REQUEST

Current Zoning: B-2(CD) (general business, conditional)
Proposed Zoning: B-2(CD) SPA (general business, conditional, site plan amendment)

Approximately 2.25 acres located on the north and south side of Northlake Creek Drive, west side of Reames Road, and south side of West W.T. Harris Boulevard.

The petition proposes to amend an existing approved rezoning site plan to allow for the development of EDEE and commercial uses with accessory drive-through lanes on two out parcels within an existing shopping center.

SHEET NUMBER:
RZ-2

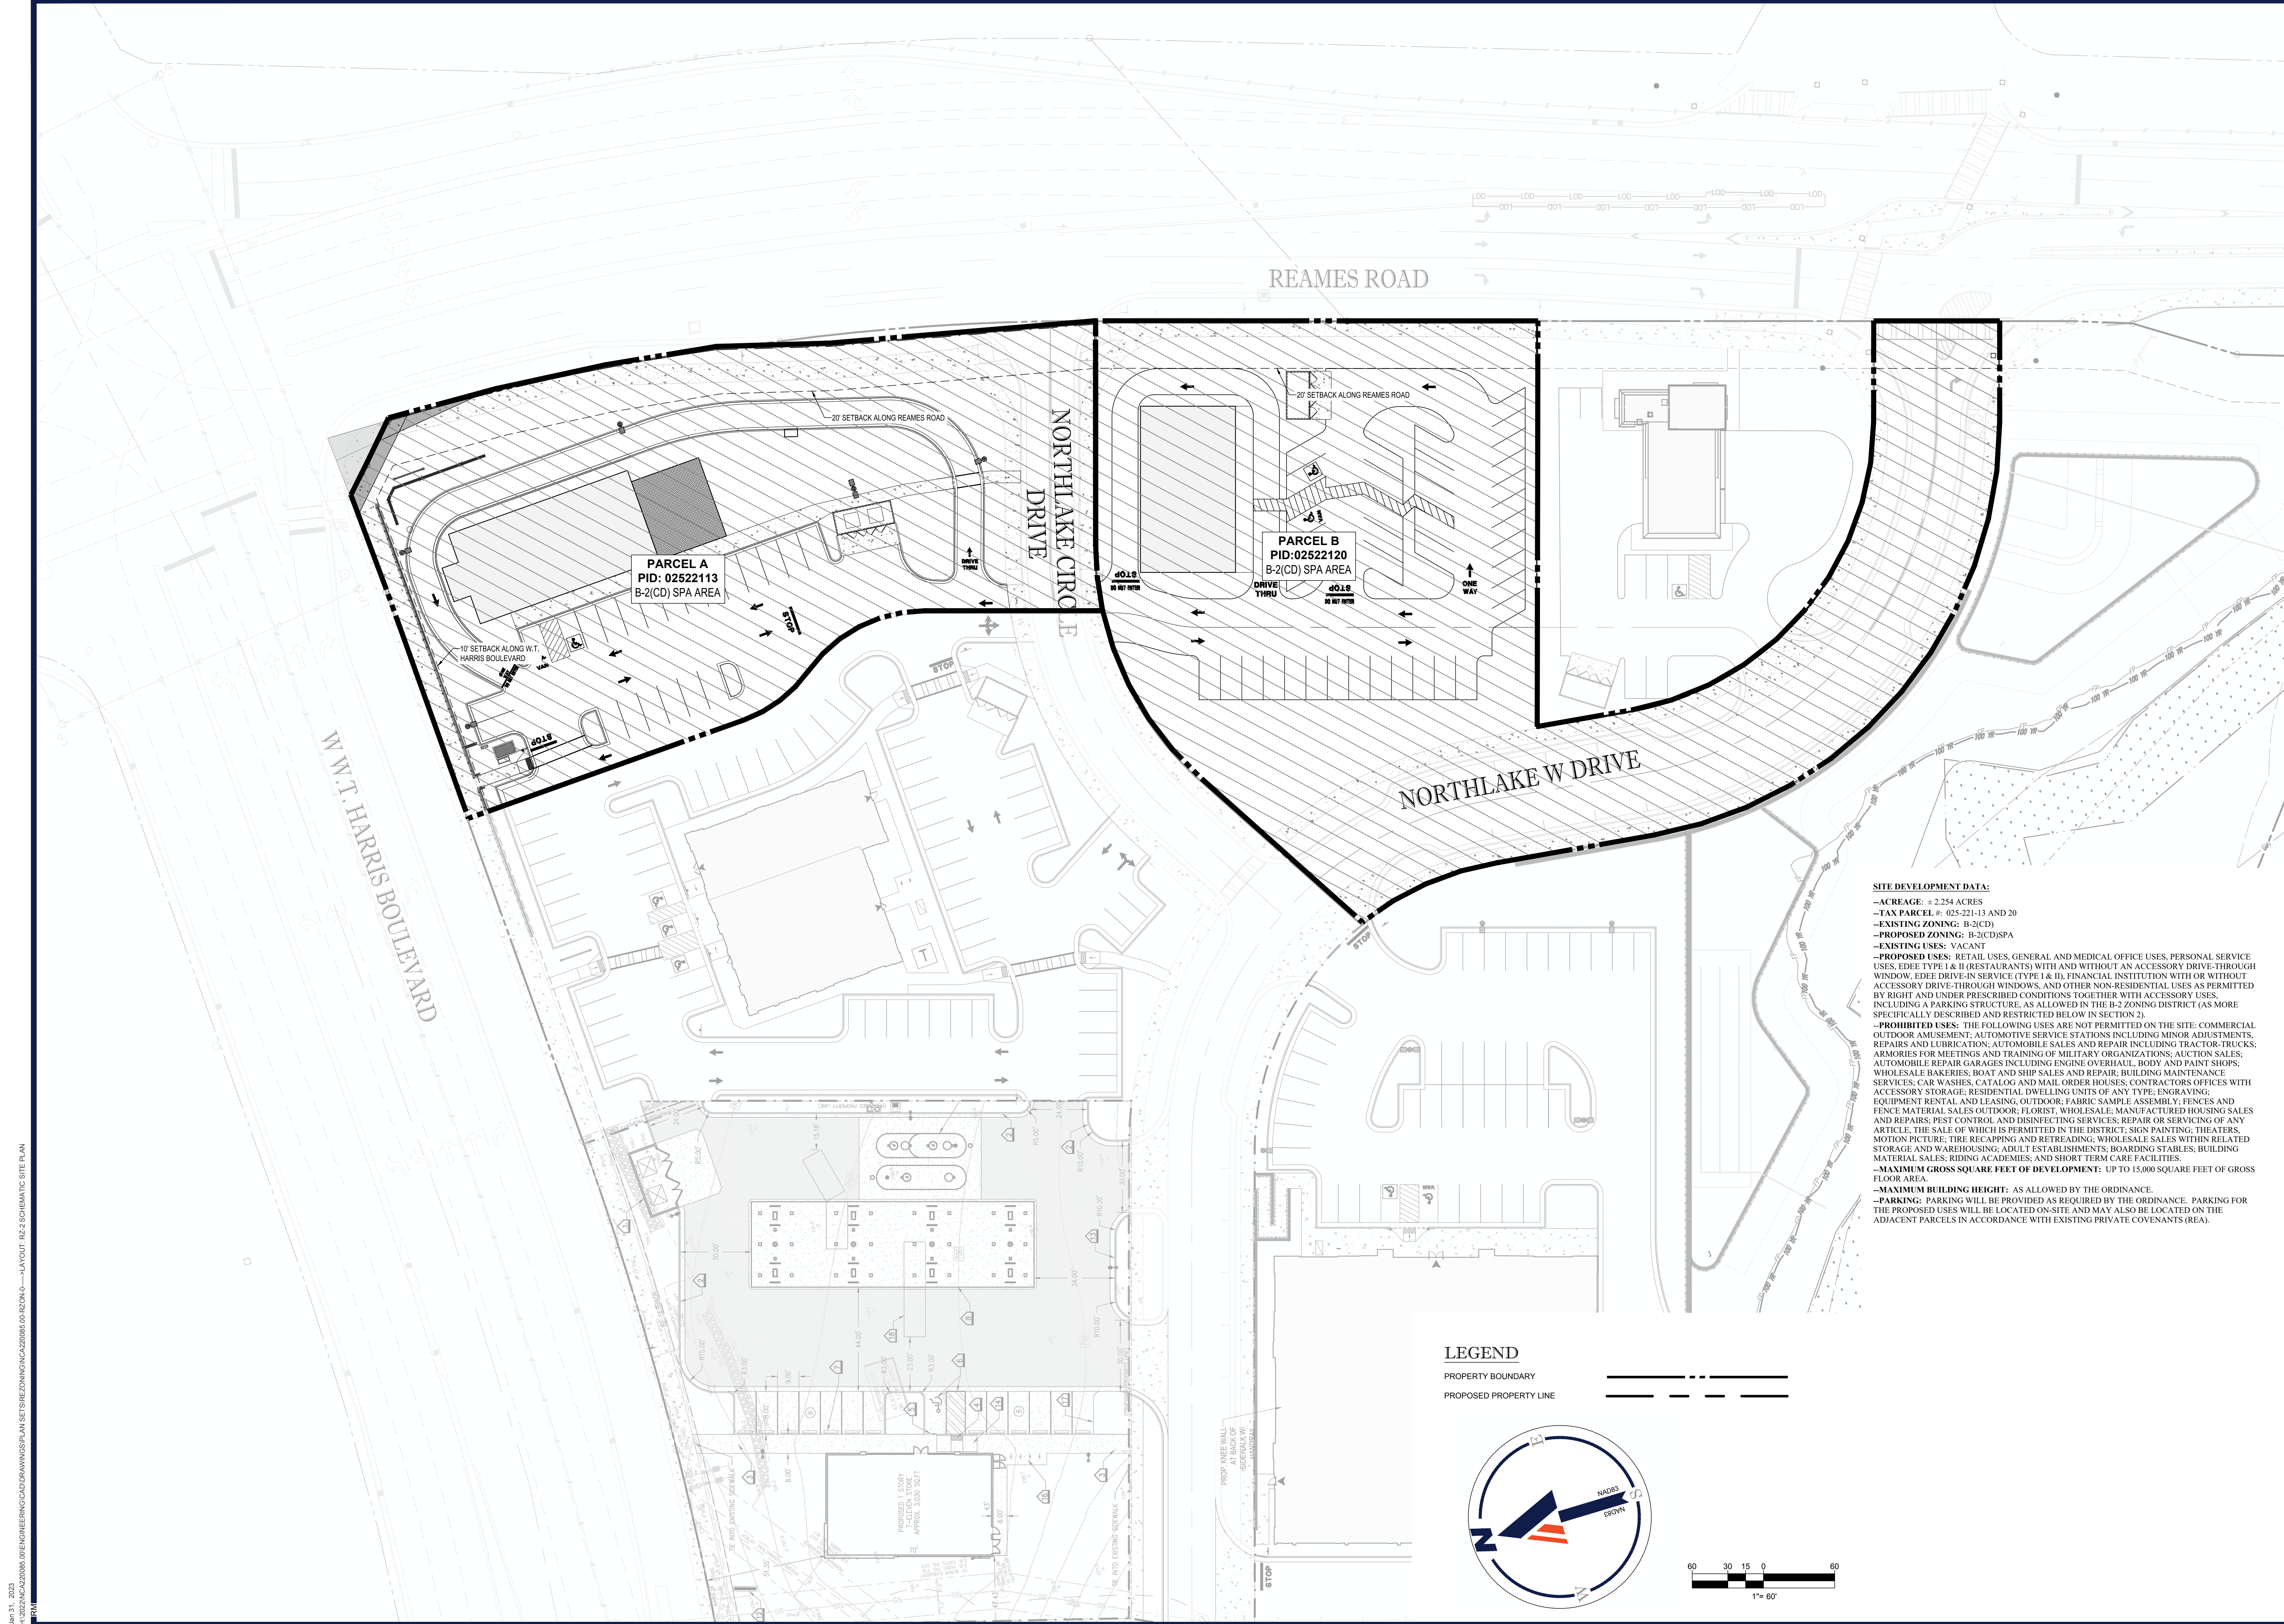
1. W T Harris Blvd: Location of future back of curb and gutter to be 44 feet from roadway centerline to accommodate the Charlotte Streets Map with a roadway typical section of 6+ Boulevard, Shared Use Path.
2. Reames Road: Location of future back of curb and gutter to be moved to 38 feet from roadway centerline to accommodate the Charlotte Streets Map with a roadway typical section of 4+ Avenue, Buffered/Separated Bike Lanes.

3. The proposed site plan shows two principal structures on the site, while the conditional notes refer up to four proposed principal structures. The proposed number of structures shown on the site plan and noted in the conditions must match.
4. Staff recommends that the site plan be revised to incorporate design elements that would increase the consistency of site with the design requirements of the Regional Activity Center Place Type such as relocating the drive-through lanes so that they are not located between the buildings and the street.
